**From:** Megan McKay <MMcKay@johnstonarchitects.com>  
**Sent:** Thursday, February 2, 2023 10:27 PM  
**To:** Andrew Leon  
**Cc:** Stephen S. McKay; Megan McKay  
**Subject:** SUB22-006 Comment

We have reviewed the SUB22-006 development application and have concerns about the work in the ROW proposed, which extends in front of our house.

**EXCEPTIONAL TREES ON ALL LOTS:**

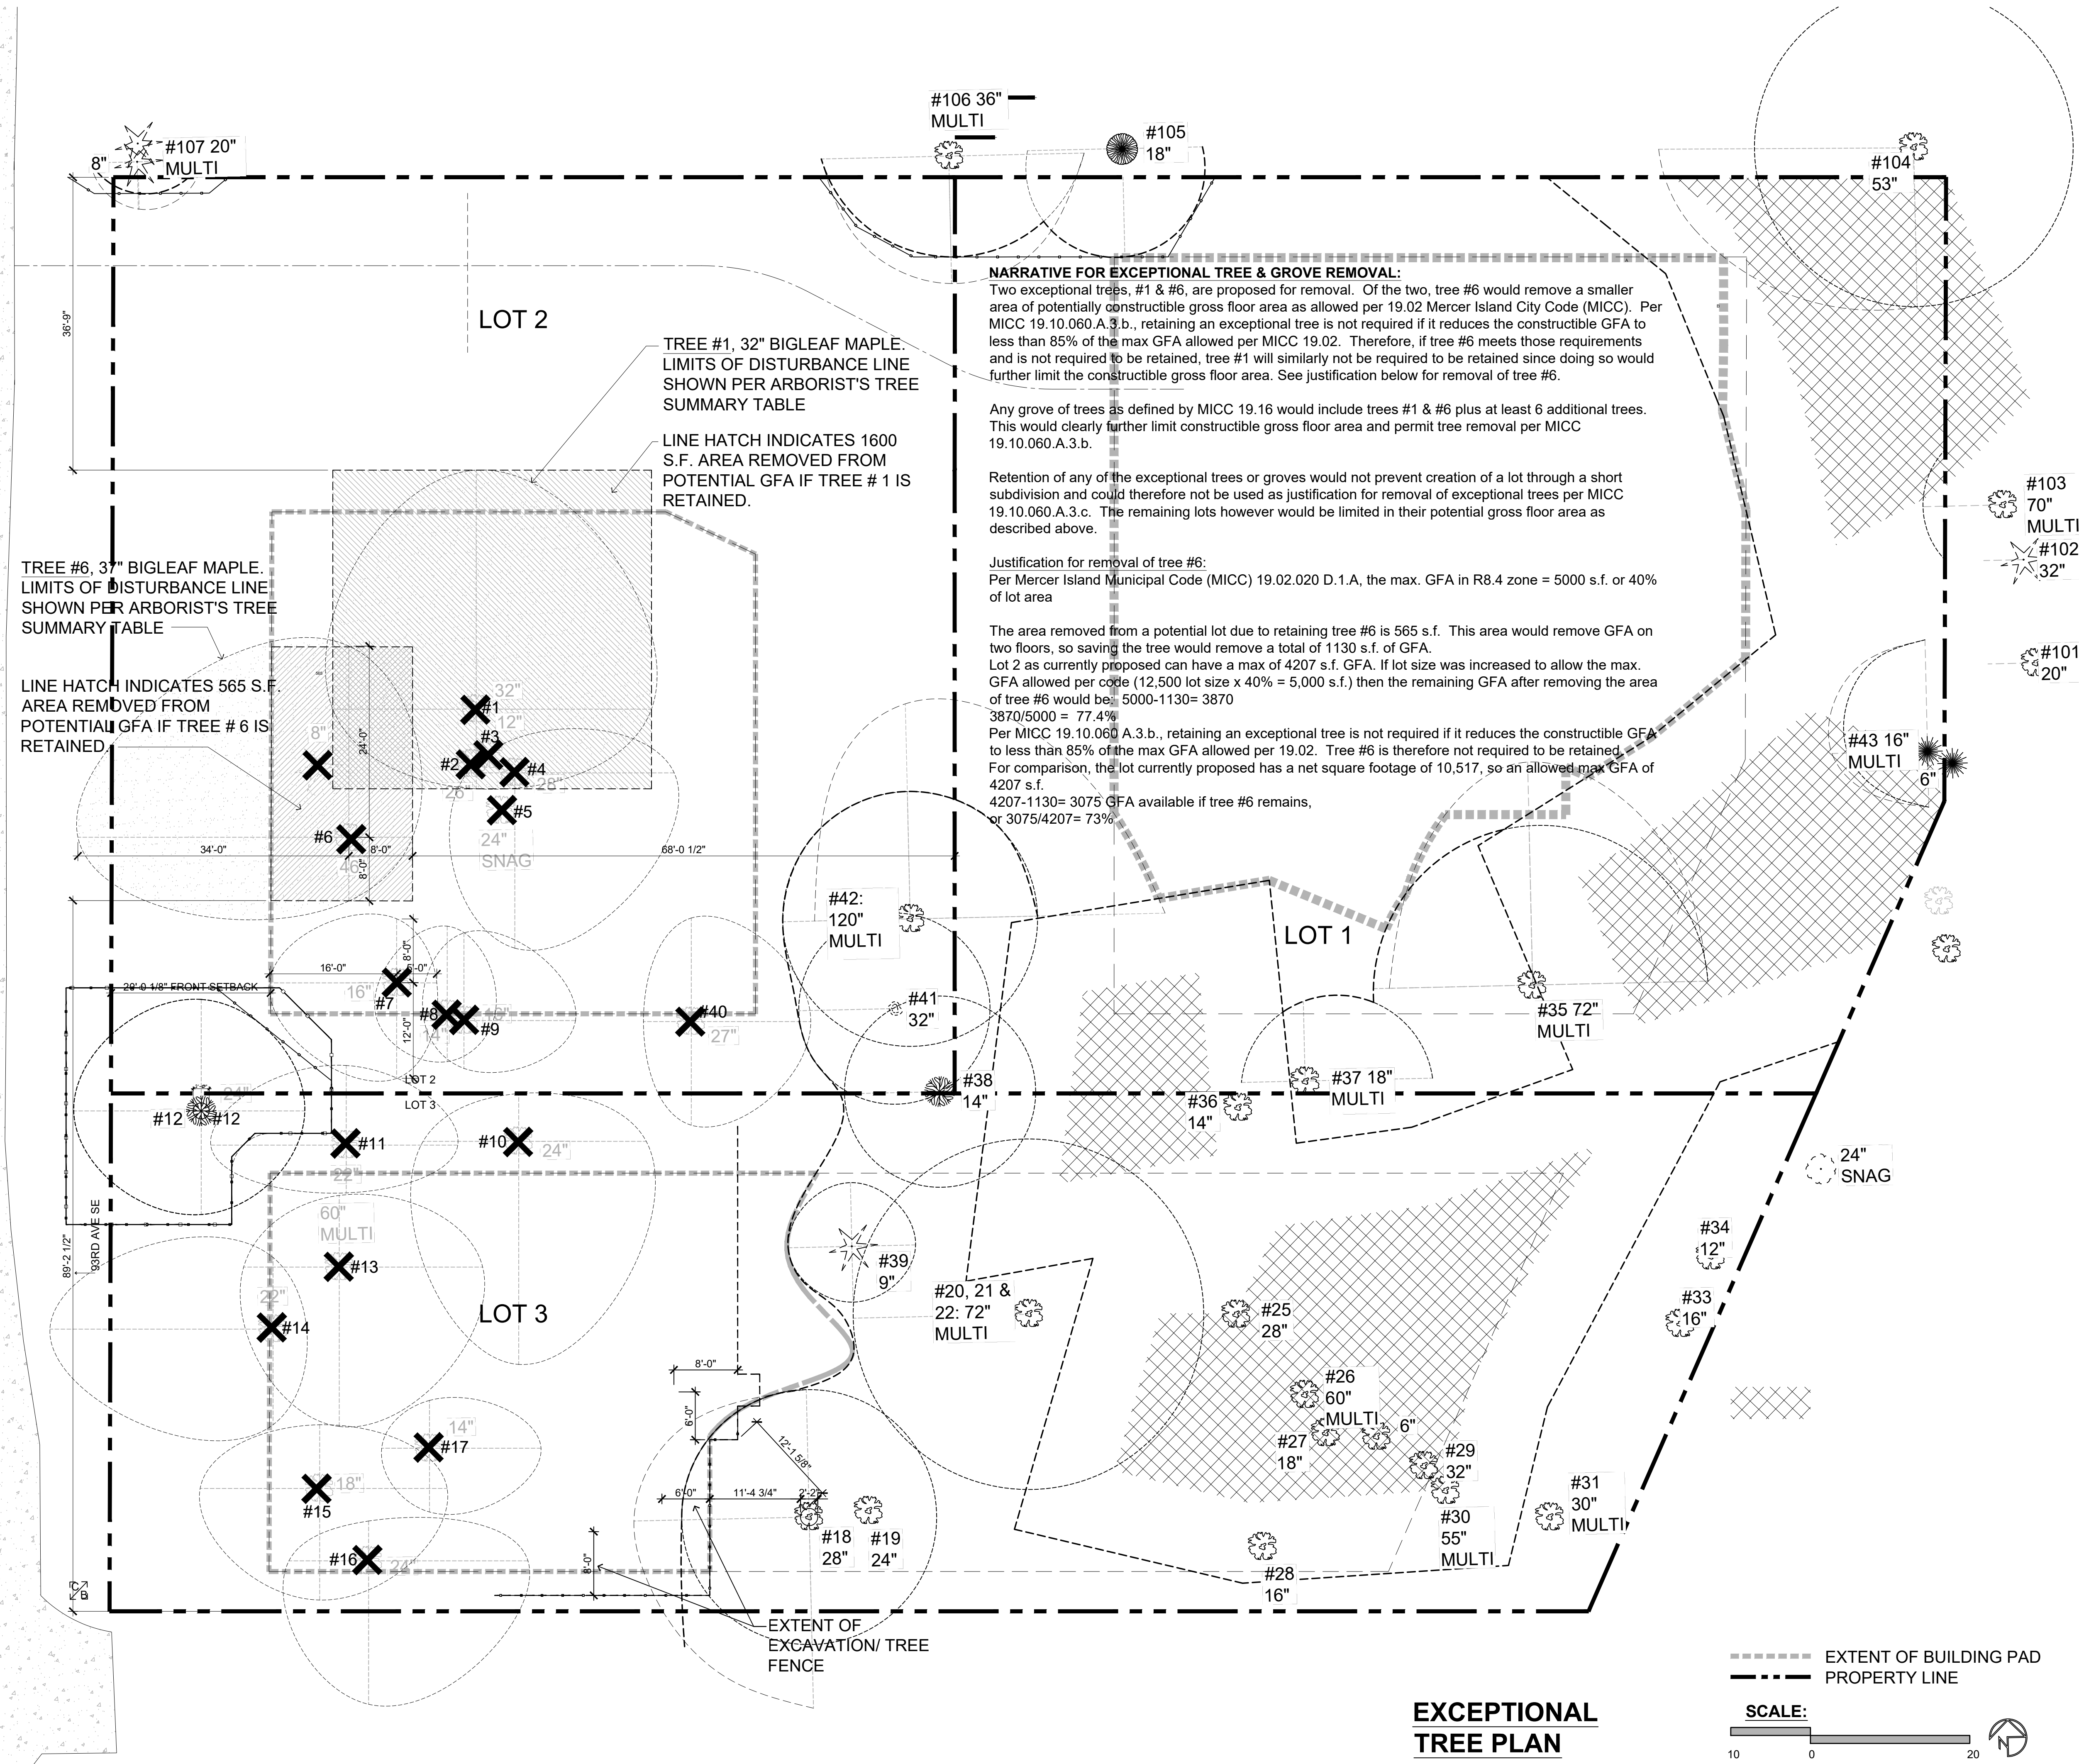
Lastly, we note with despair that the Applicant is proposing to remove two "Exceptional" trees. We understand that some tree removal is unavoidable with new development, however, the proposed new home massing on Lot 2 should be required to be less block-like and more sensitively sited. For example, an L-shaped home footprint should be proposed to preserve Exceptional Tree #6—one of the largest trees on the property—at minimum.

**PRELIMINARY CIVIL SITE PLAN**  
**SHORT PLAT - 93RD AVE SE**  
**SUB22-006**  
PREMIUM HOMES OF MERCER ISLAND LLC  
MERCER ISLAND, WA 98040  
(206) 724-1072

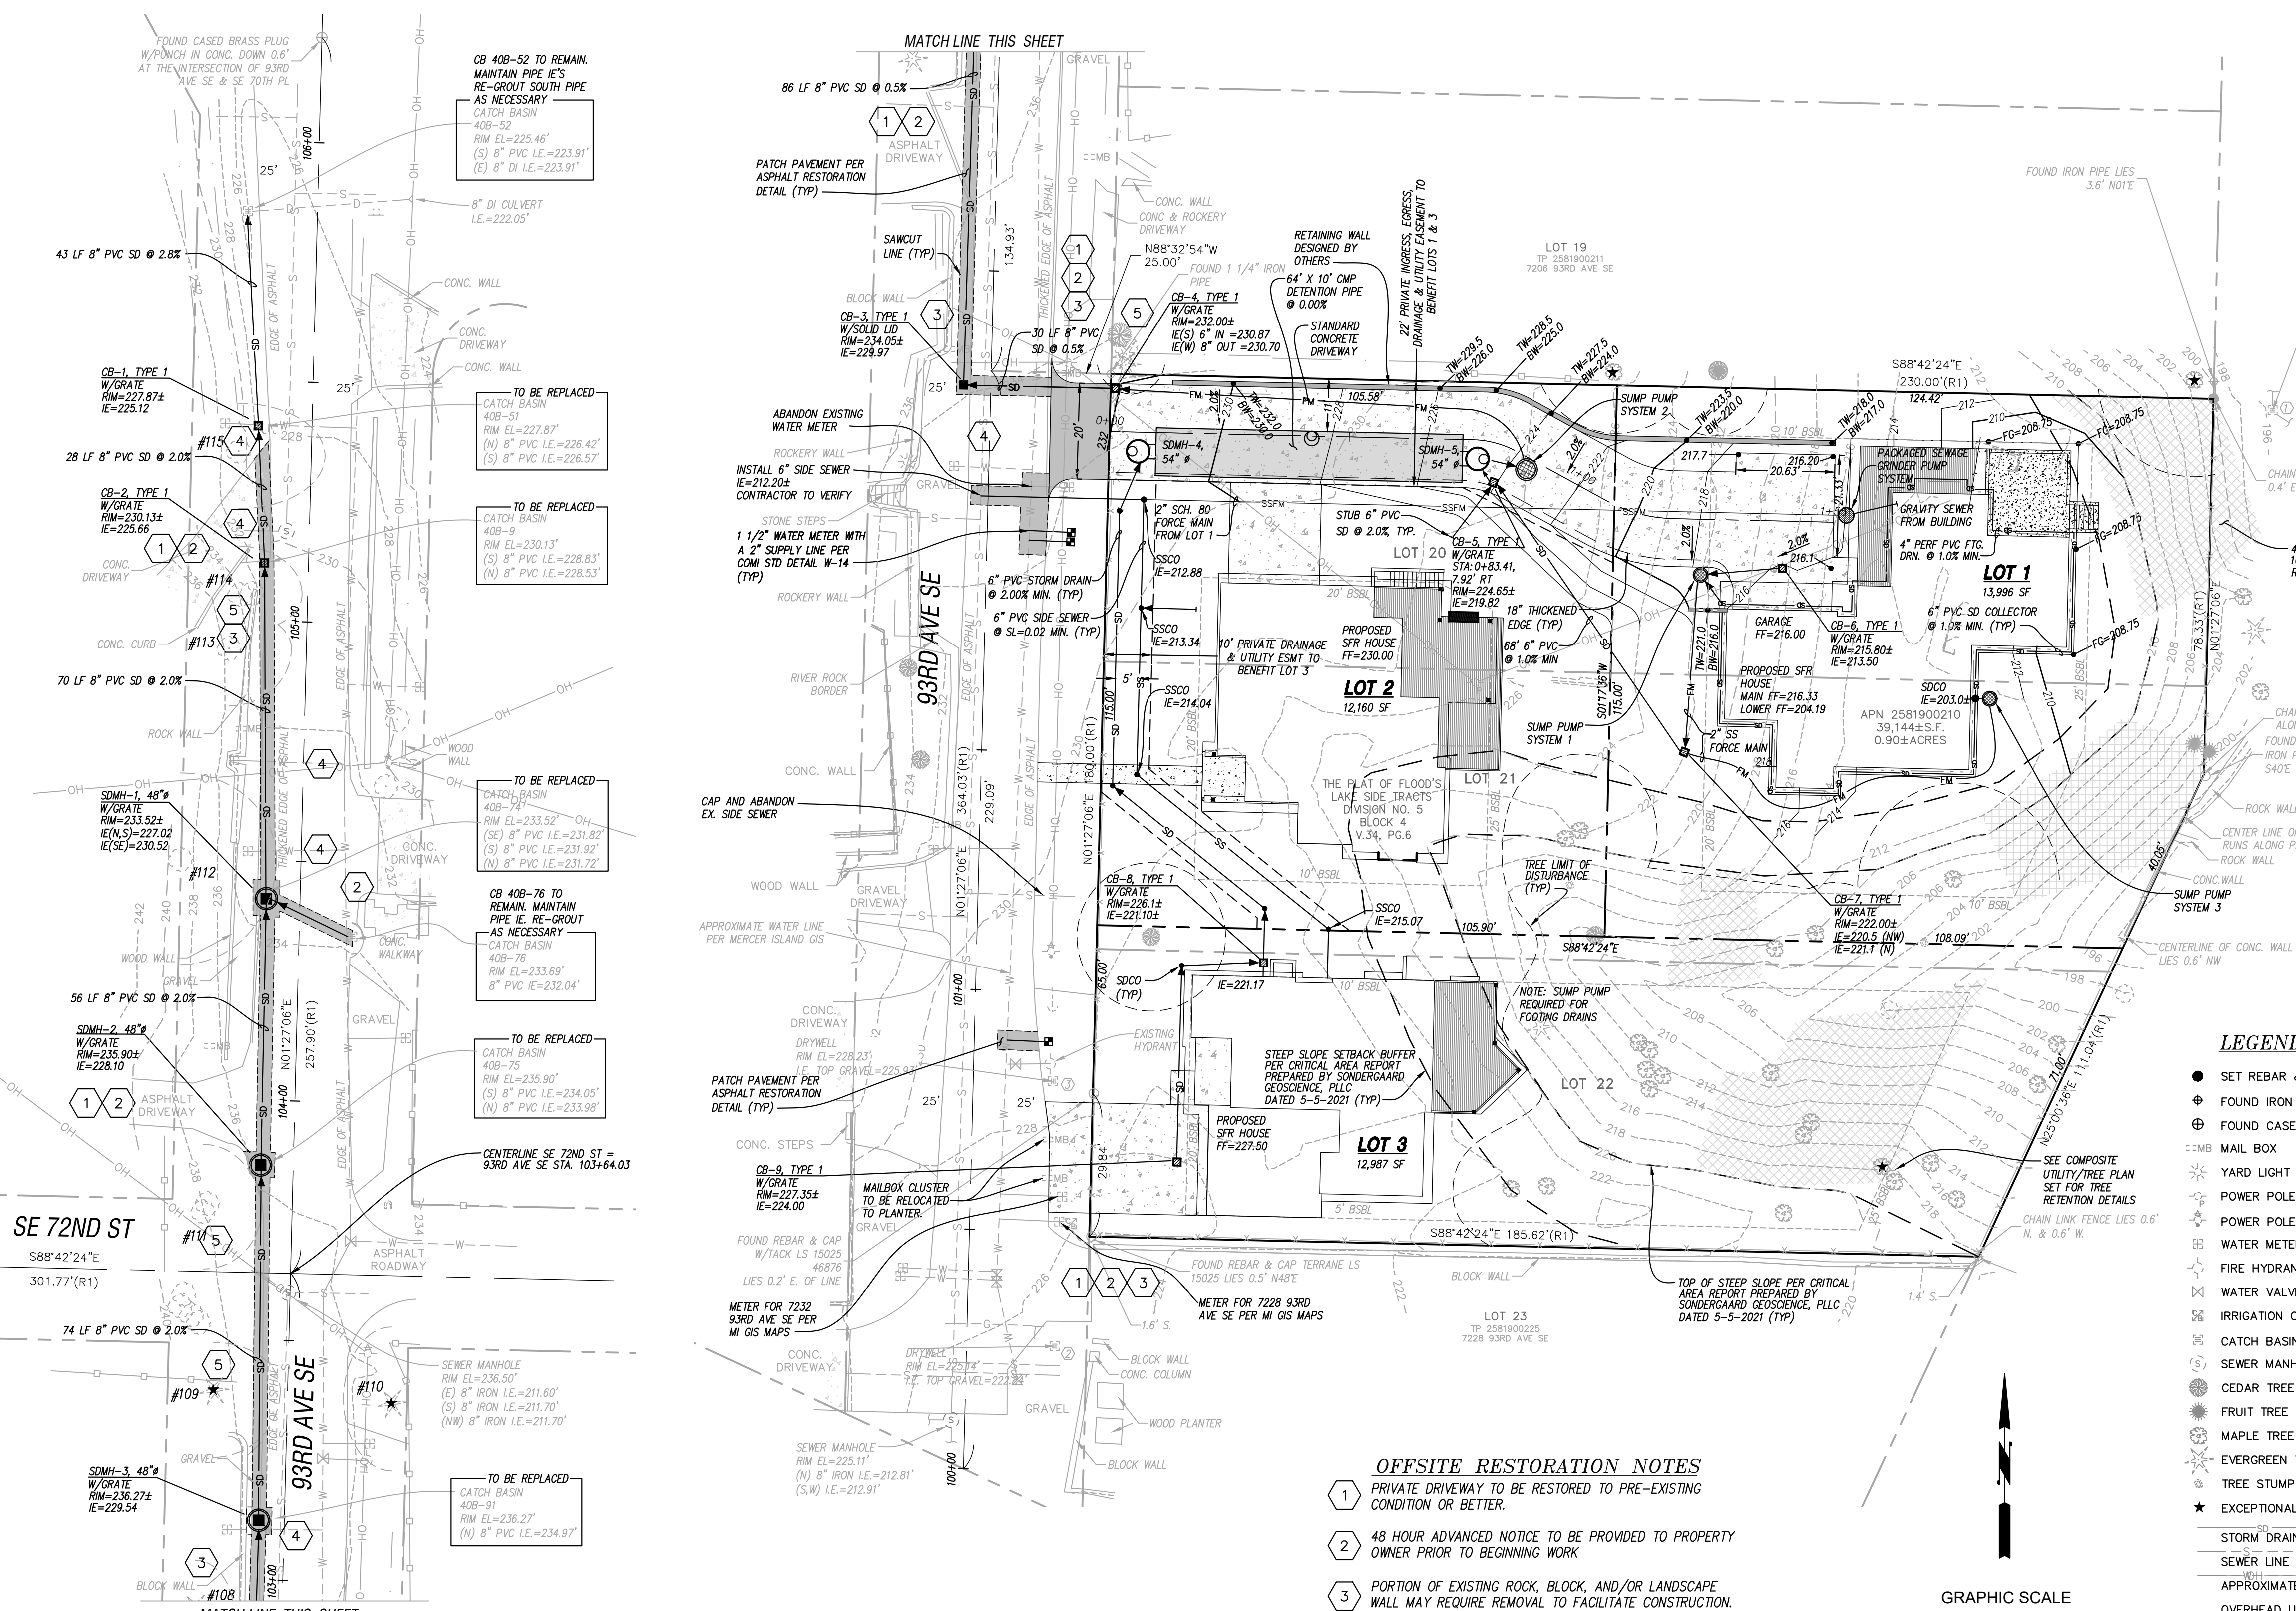
The linear cutting and patching and obliquely-angled utility street crossing proposed will lead to long-term maintenance problems with asphalt on our street, including risk of differential settlement of the patched areas leading to greater ongoing occurrence of potholes. To minimize maintenance issues for years to come, a full-width grind and overlay should be required, especially at areas of full street crossings. The existing street surface of 93<sup>rd</sup> Ave SE south of 70<sup>th</sup> is in extremely poor condition with numerous potholes and will completely fail under the heavy construction traffic anticipated for this project. The patched surface proposed by the developer is not acceptable. Furthermore, our street is not on the City's 6-year improvement plan.

We also want to make sure provision is made for construction truck turnaround on this dead-end street and appropriate care taken to protect adjacent property frontage. The connection at SE 72<sup>nd</sup> is extremely narrow (trucks will cut the corner and run off the pavement surface trying to hammerhead turn in this location) and the paving on 72<sup>nd</sup> is failing condition. What penalties will be imposed if nearly inevitable construction-related damage is caused and how can the City ensure the streetscape is left in acceptable condition?
